Project Name: **Construction of new four-unit residential condominium building**

Level III Subdivision and Site Plan

Project #: #2016-005

Address: 31 Fore Street, Portland

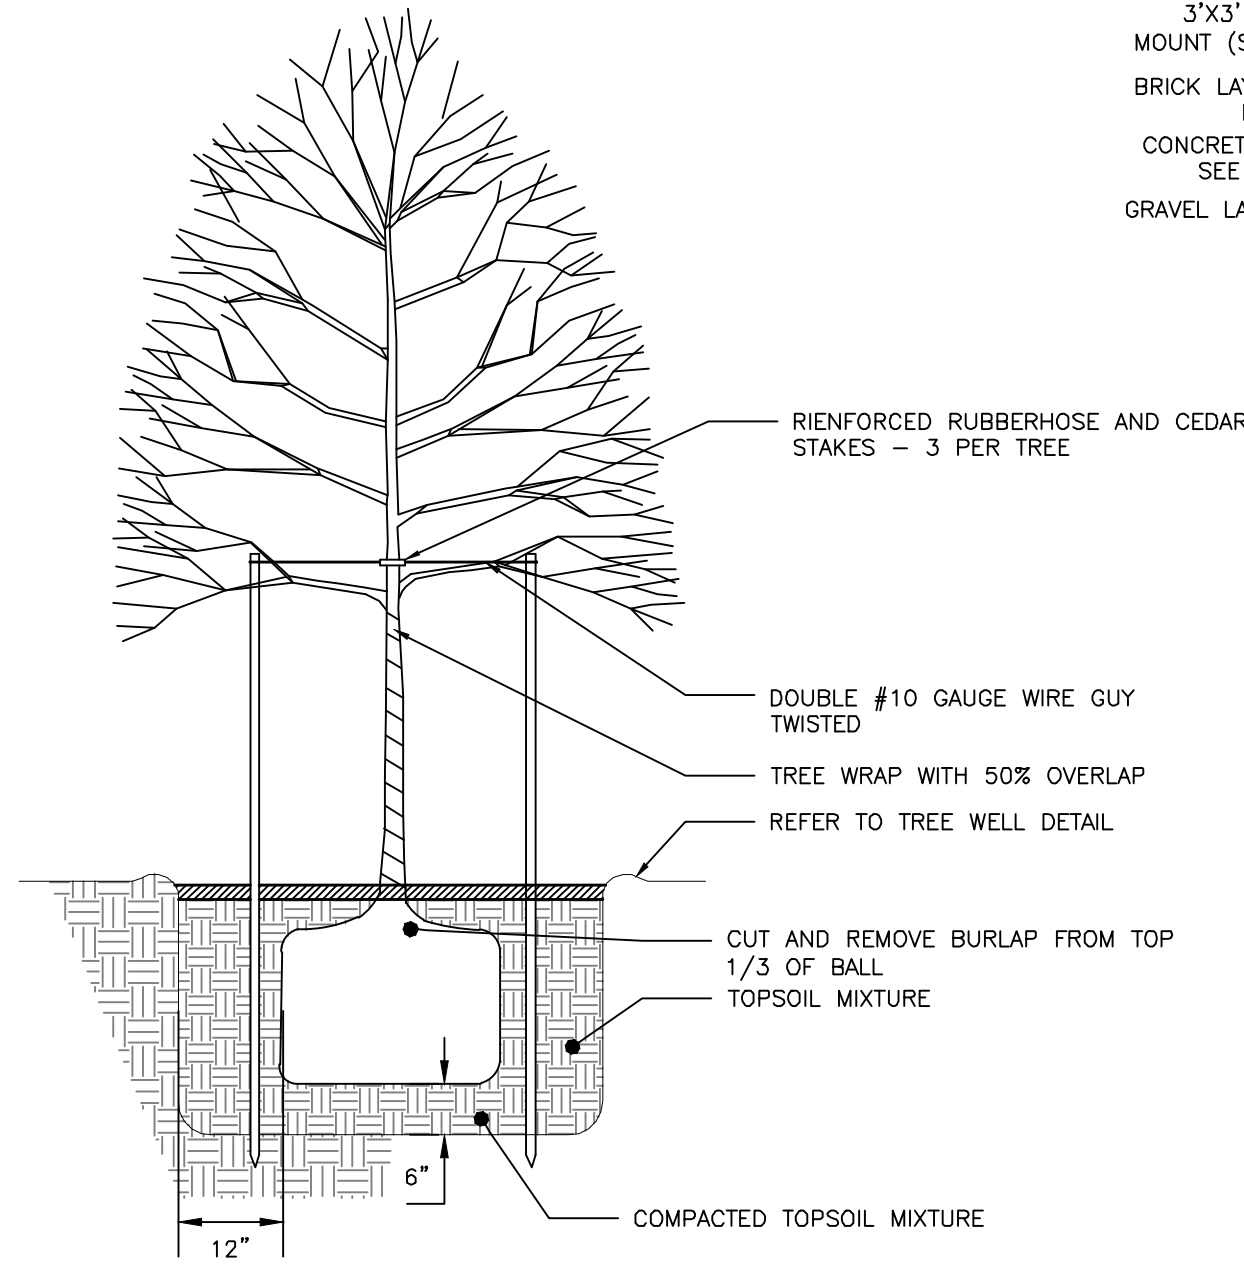
- iv. That the applicant shall take all measures to protect the existing street tree on Fore Street as recommended in the City Arborist comments dated 3.16.2016; and

BICYCLE HITCH DETAIL
NOT TO SCALE

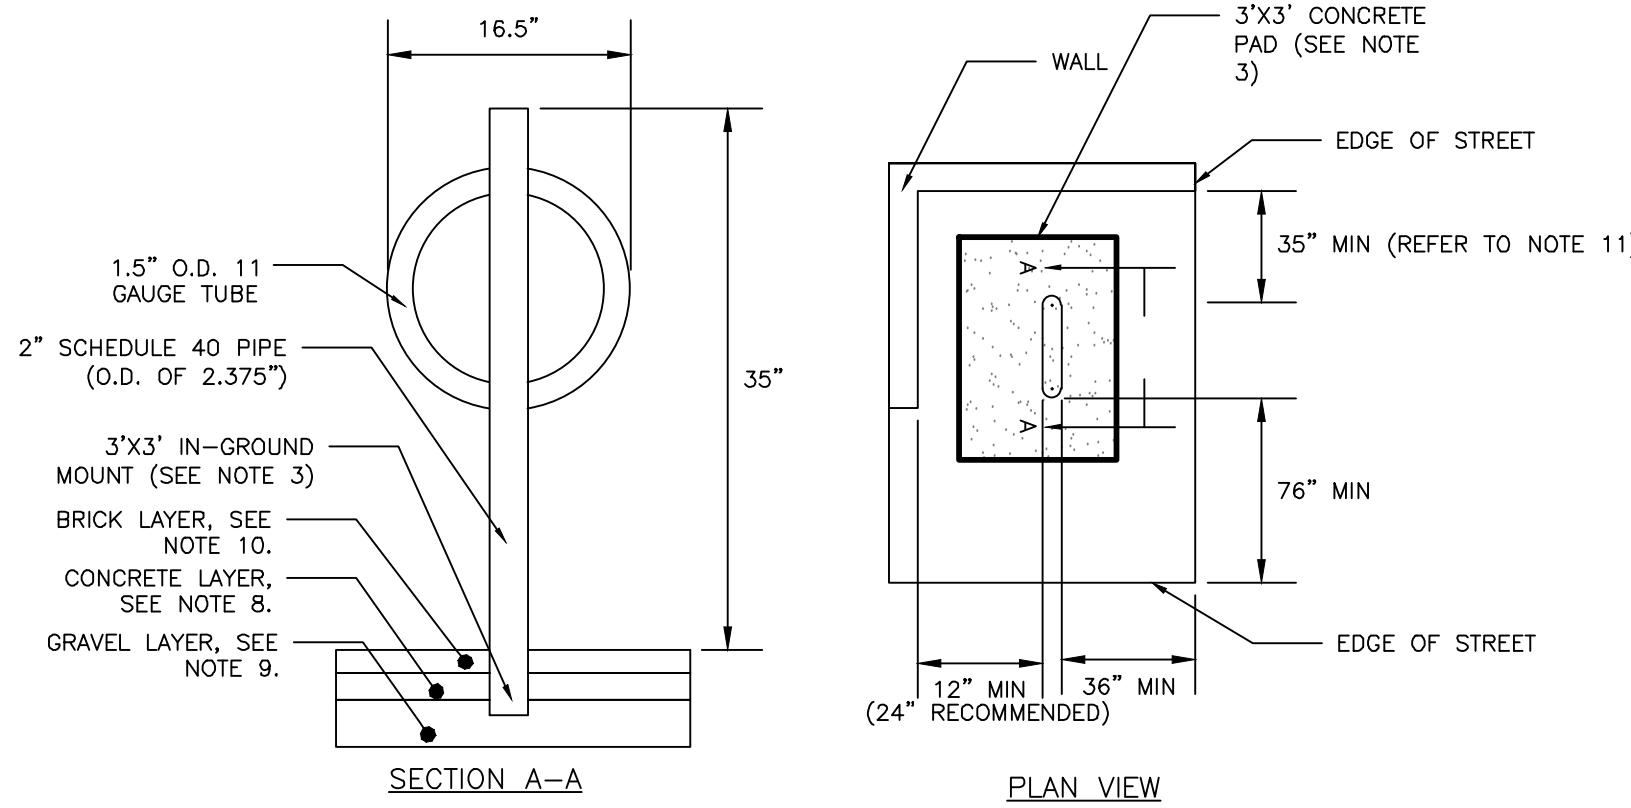
- b. Ensure that the bicycle parking hitches in the ROW are designed to meet the Technical Standards; and
  - c. Show that the design of the balconies will direct drainage and ice/snow so that it will not fall on the sidewalk.
